Mr. Harvey Chen

Discussion of findings and processes regarding the trees on King County parcel 1924059317

In response to city comments on your project we offer the following information.

ARBORISTS SITE PLAN
 1" = 10'-0"

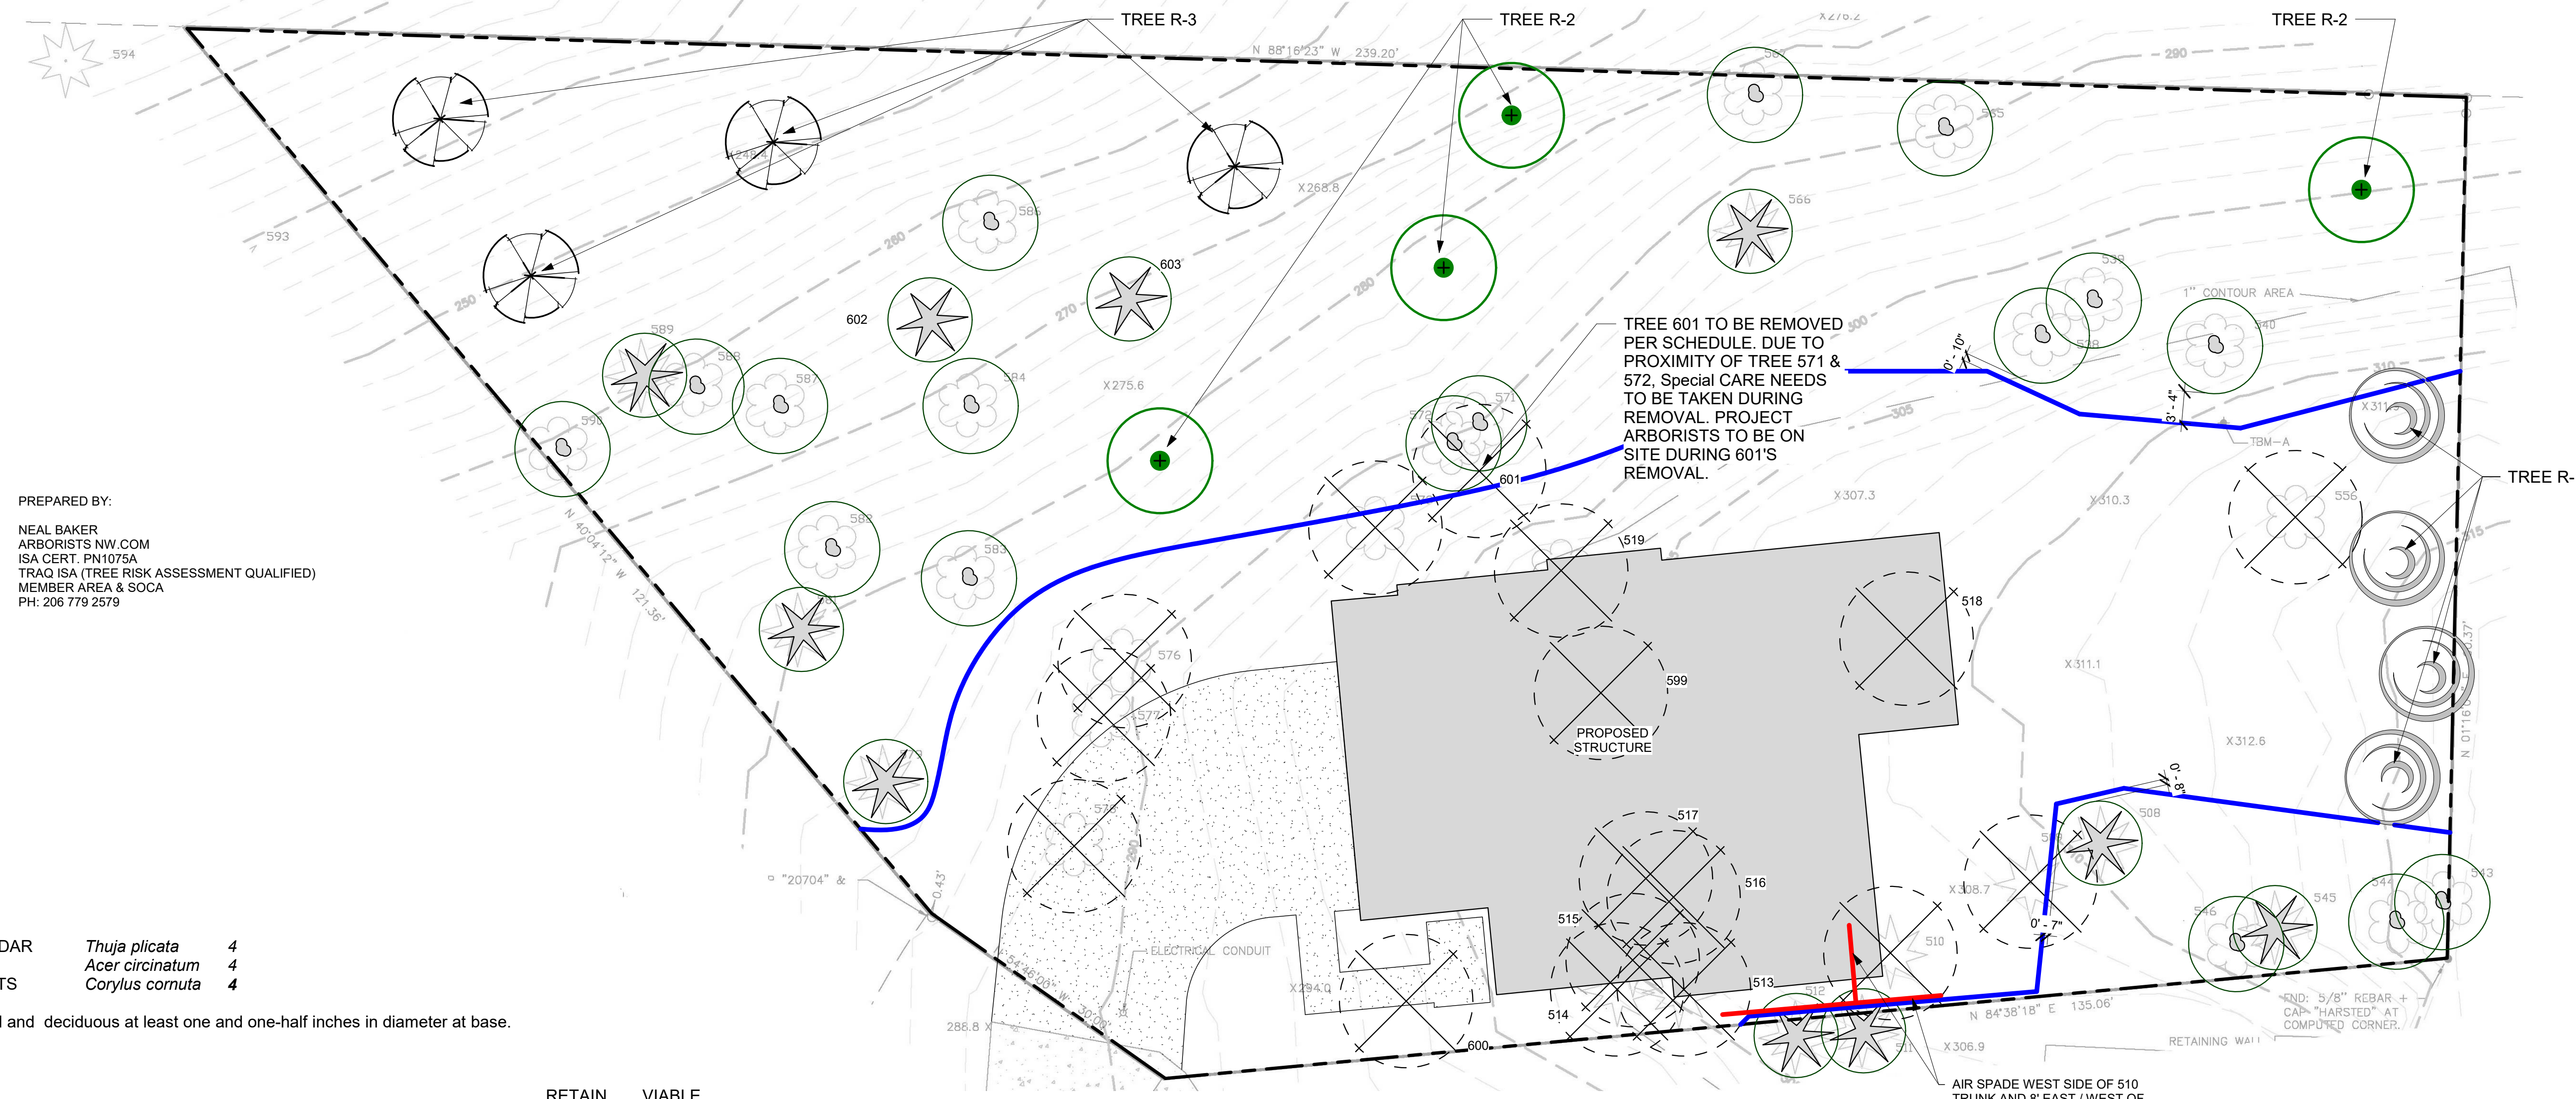
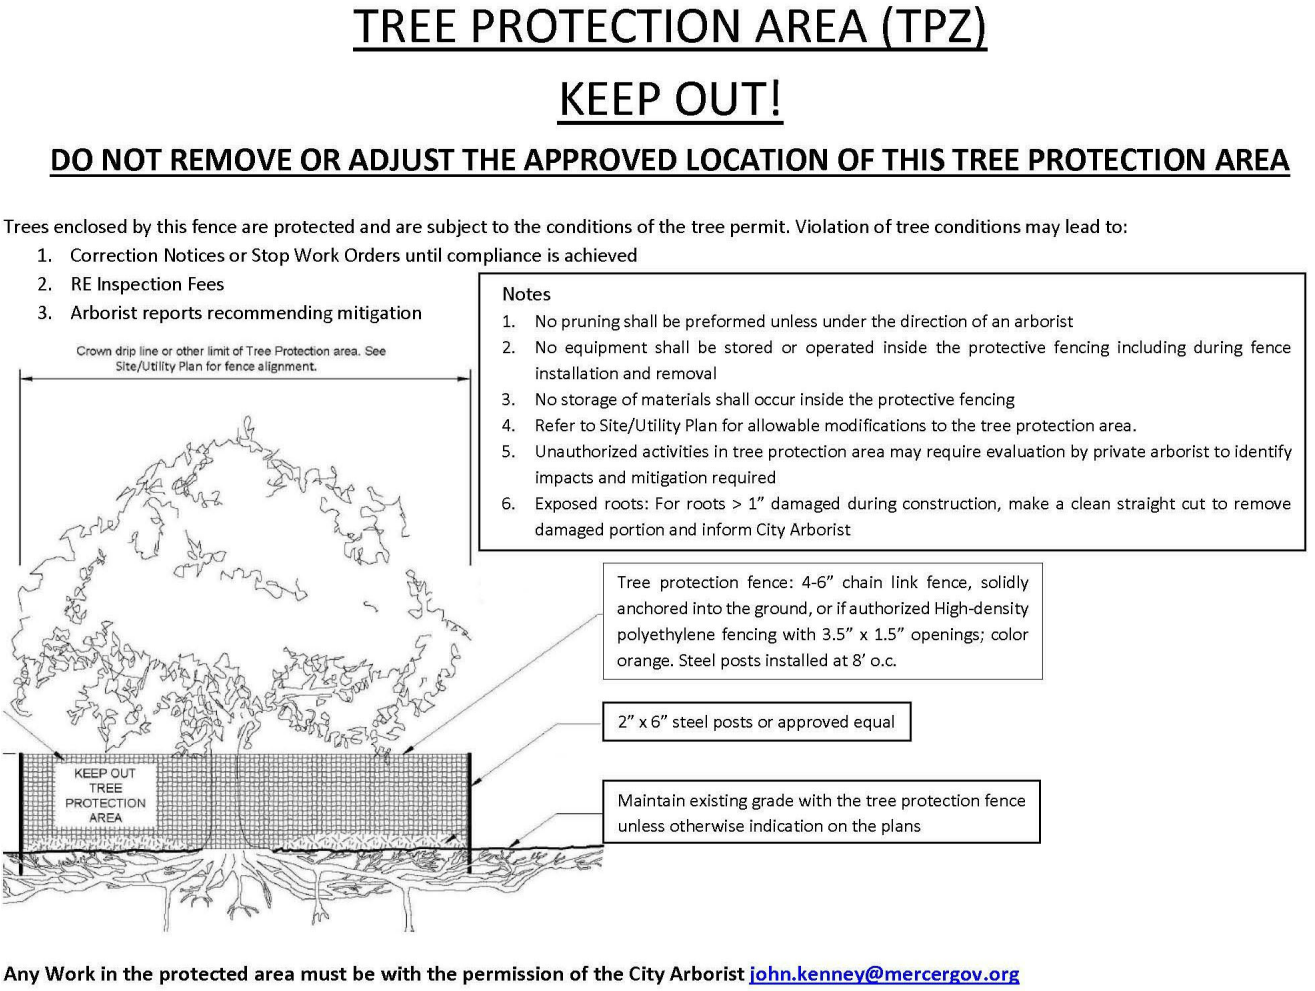
Tree #510 a 36.5" DBH Douglas Fir (*Pseudotsuga menziesii*). Special attention was afforded this tree as it needs to be removed to position the proposed building as designed and is an exceptional tree as defined by city regulations. At first glance the tree appears to be in good condition. Good color foliage and no obvious deadwood. However, the tree has Butt Swell and this drew extra attention. Butt swell is a symptom of an internal weakness as the tree adds tissue to itself to overcome the weakness. Using a 27" long Haglof increment Bore, 2 sample were pulled from the tree. One on the East side and the other on the West side. Full length core samples could not be obtained as the tree has a cavity and decayed wood. The sample from the west side was 7" long with the tissue at the end of the core discolored and crumbling. Even while adding extra force to the borer it would not advance deeper and the tissue if any were in place it was not firm enough to let the bore grip and dig into the tree. The core on the east side of the tree was 11" long. The first 2.5" was sound wood (wood without defect), after this the tissue dried out and became discolored, then finally turned brown and crumbled. Again, the bore was unable to grip the remaining tissue and bore deeper. The International Society of Arboriculture standard for minimum sound wood is 30%. Averaging the 2 cores to a length of 4.75" puts the sound wood percentage of this tree at 12.32. One more measurement of the diameter was taken above the butt swell at 6' the diameter at this height is 31" for a 4.5" difference in a foot-foot and a half travel up the trunk. In my opinion that is drastic. Further inspection using an air spade to a depth of 18" revealed that the "root flair" had been buried more then a foot deep and close to 15-6" deep. This in my opinion is a contributing factor that allows me to recommend removal and replacement of this tree. Our team's speculation is that the neighbors when their home was being build piled fill around the tree from their much lower and level back yard.

Trees 511 & 512 Exceptional Douglas Firs on neighboring property. The proposed building foundation is with the dripline of the trees. Air Spade work was done 8' from the trees to a depth of 18' from tree 510 to a point outside of the dripline to the west. No roots were found connected to these trees. It is my opinion that tree protection fencing be positioned at the trench formed and the tree will flourish after construction.

Tree # 518 A 2 trunk 30" DBH Big Leaf Maple has one trunk completely dead and removal is planned.

Tree # 519 a Exceptional 36" DBH Big Leaf Maple is in advanced decline, dead scaffolds and several undermined. It appears that the tree had grown on a nursery log or stump and that has now rotted away. There are gaping holes under the trunk.

Tree # 556 A 36" DBH Big Leaf Maple (*Acer macrophyllum*) has 7 dead scaffold branches and epicormic sprouts on the stump. Given the amount of dead wood in the tree and this species susceptibility to decay, I recommended that this tree be removed and replaced if needed.

Trees #601-3 Are dead decaying stubs standing on the slope to the north. The slope is so steep here that if these tree fall hitting the homes below them is inevitable. If they do not hit directly, pieces rolling down the slope is probable given the degree of the incline. Getting these trees cut to ground and left in place is recommended.
